Our ref: HA/2017/119828/02-L01
Your ref: LU/307/17/PL
Date: 21 November 2017

ADDITIONAL FLOOD RISK INFORMATION - DEMOLITION OF PROMENADE SHELTER & CONSTRUCTION OF CAFE & KITE SURFING SCHOOL WITH ROOF TERRACE & ASSOCIATED WORKS

NPA - PROMENADE SHELTER SEA ROAD, LITTLEHAMPTON, WEST SUSSEX, BN16 2NA.

Project/Address	New Kite School and Beach Cafe	DRAWING	Proposed GF Plan
Promenade, Sea Road		Drawing Note	C901.03/05
Littlehampton		Scale	1:100 @ A3
West Sussex, BN17 5GB		Date	September 2017

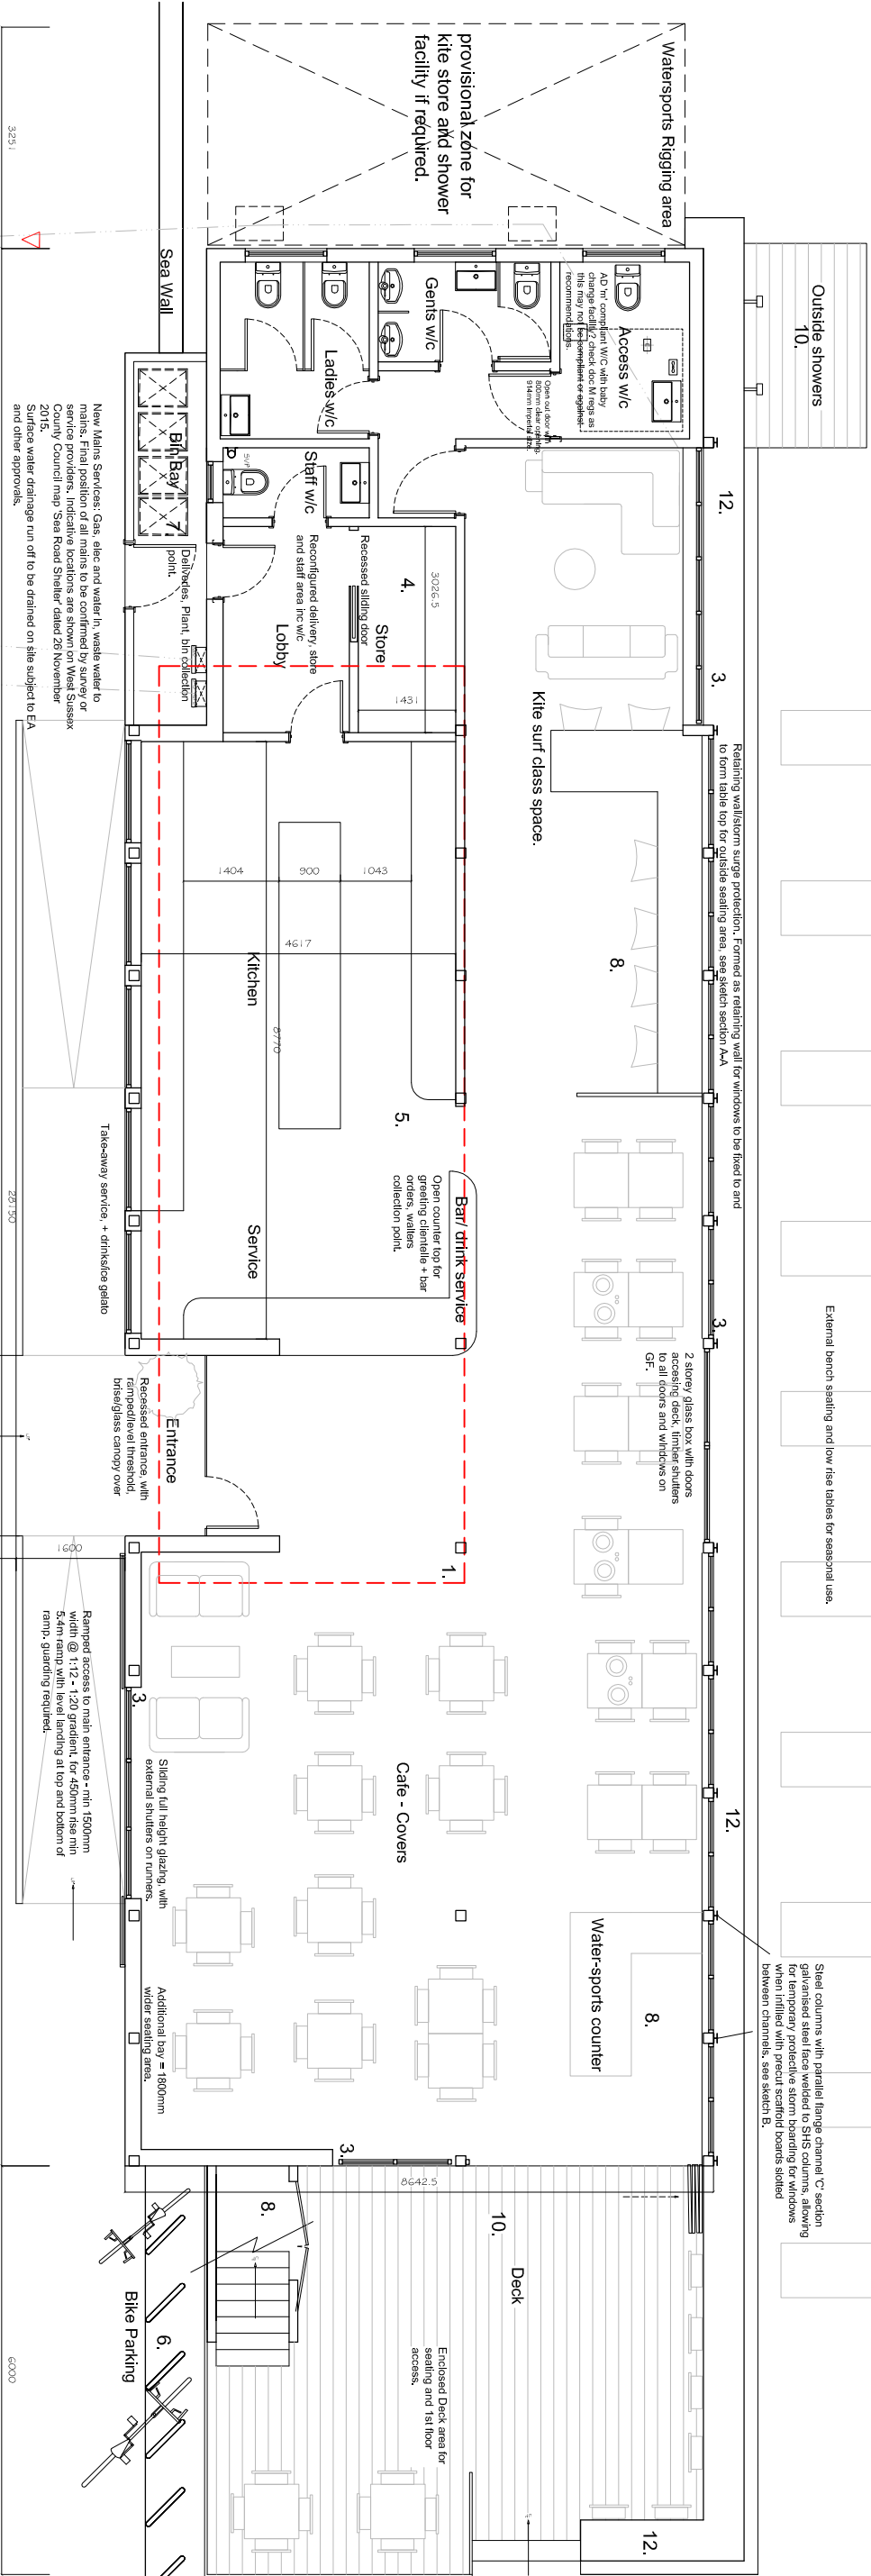
The proposed development will only meet the requirements of the National Planning Policy Framework if the following measure(s) as detailed in the Flood Risk Assessment (FRA) (September 2017) and Proposed Ground Floor Plan 05A (07/11/17) submitted with this application are implemented and secured by way of a planning condition on any planning permission.

The development permitted by this planning permission shall only be carried out in accordance with the approved Flood Risk Assessment (FRA) (September 2017) and the following mitigation measures detailed within the FRA and Proposed Ground Floor Plan 05A (07/11/17):

- ***Finished floor levels are set no lower than 5.36m above Ordnance Datum (AOD).***
